**CITY OF ALBUQUERQUE
PLANNING DEPARTMENT
November 4, 2015
DRB Comments**

PROJECT # 1009969

APPLICATION # 15-70391

RE: Lot 17-A-1, Pappé Addition

PLAT OF
 LOTS 17-A-1-A AND 17-A-1-B
 PAPPE ADDITION

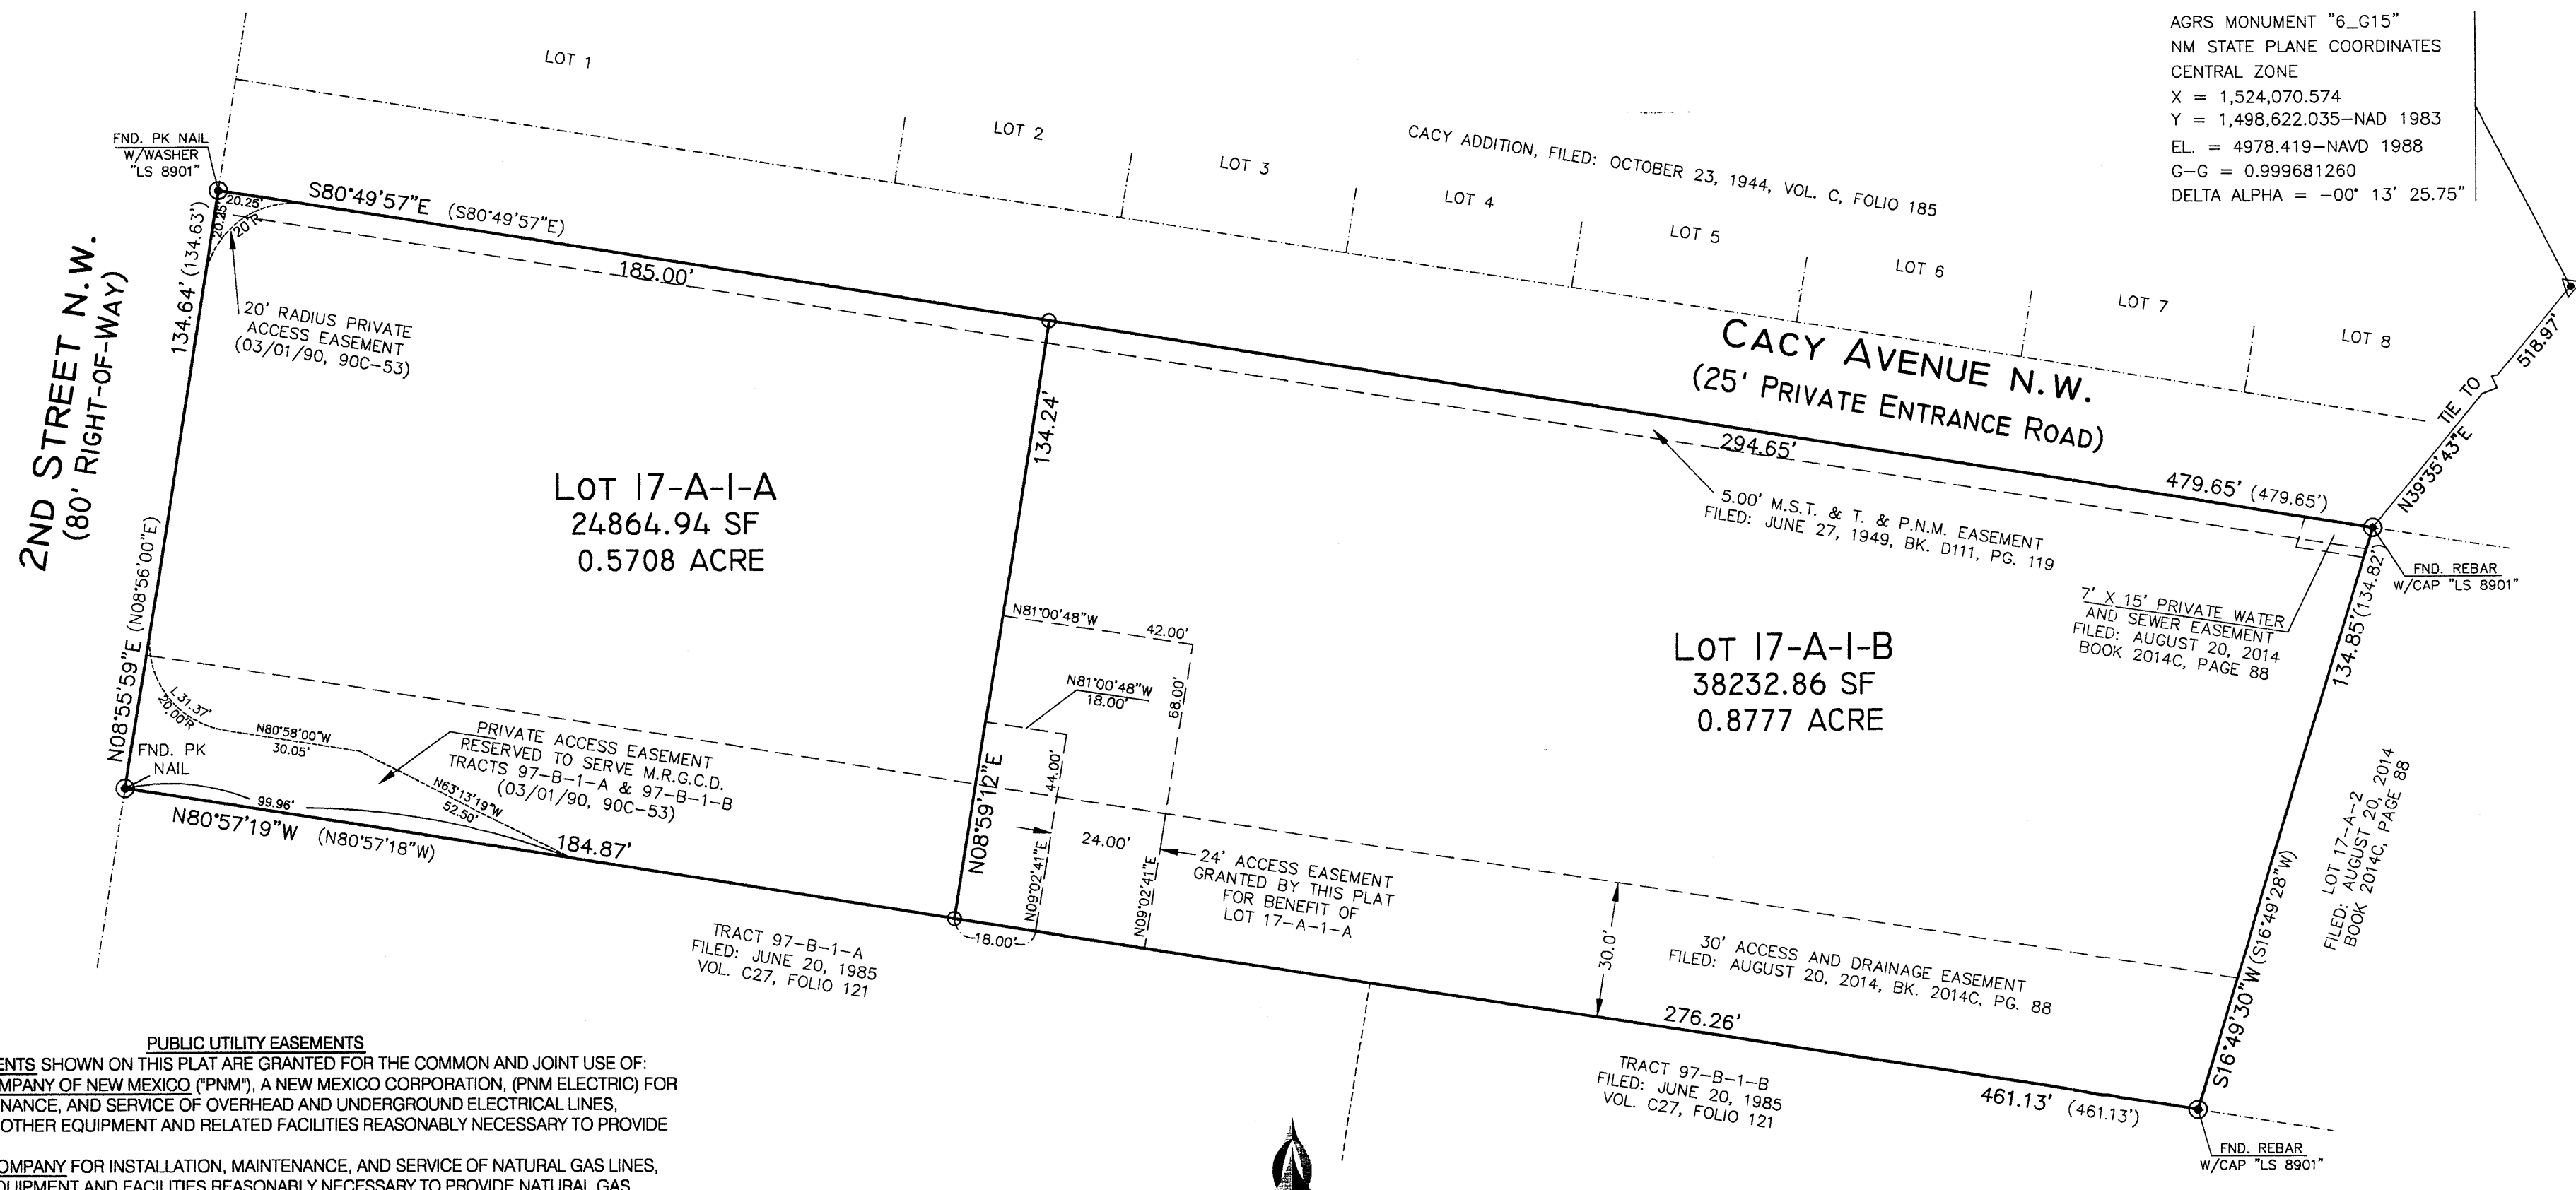
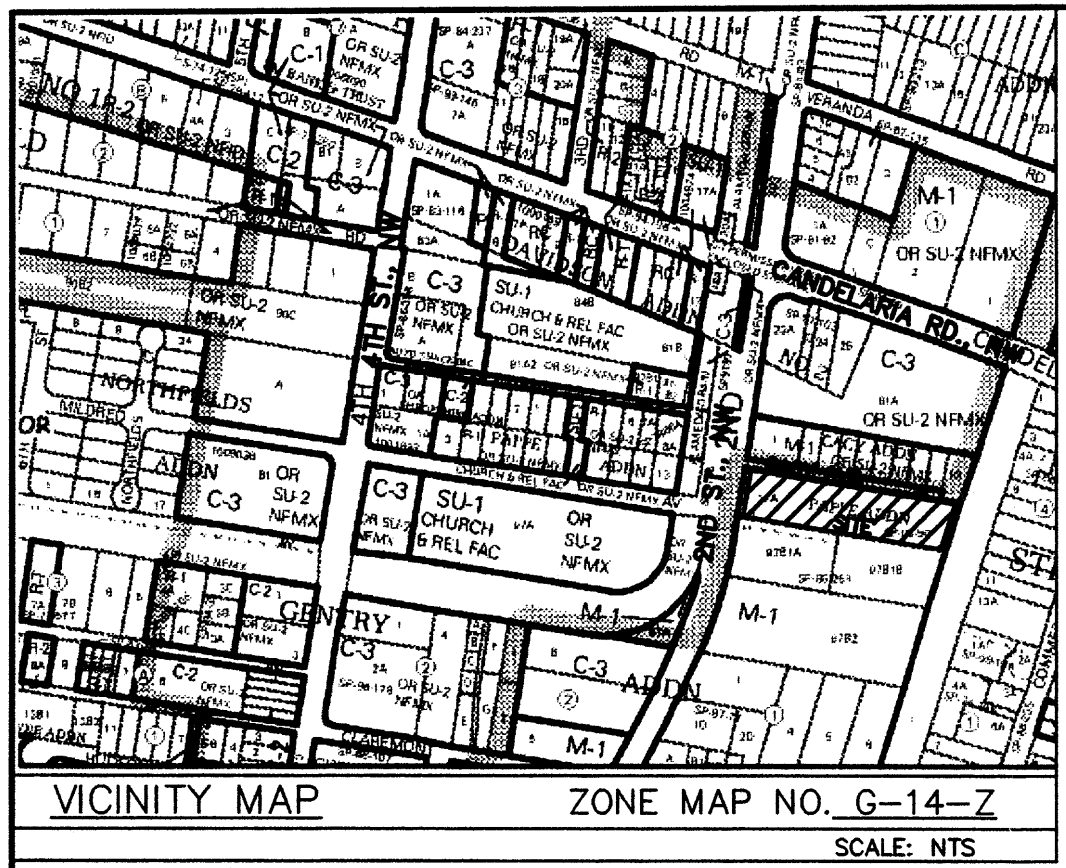
Zoning Note (No. 5) needs to be removed from Final Plat.

The 24 foot easement for proposed Lot 17-A-1-A should begin at the edge of the 30 foot easement – it does not appear that it needs to encroach,
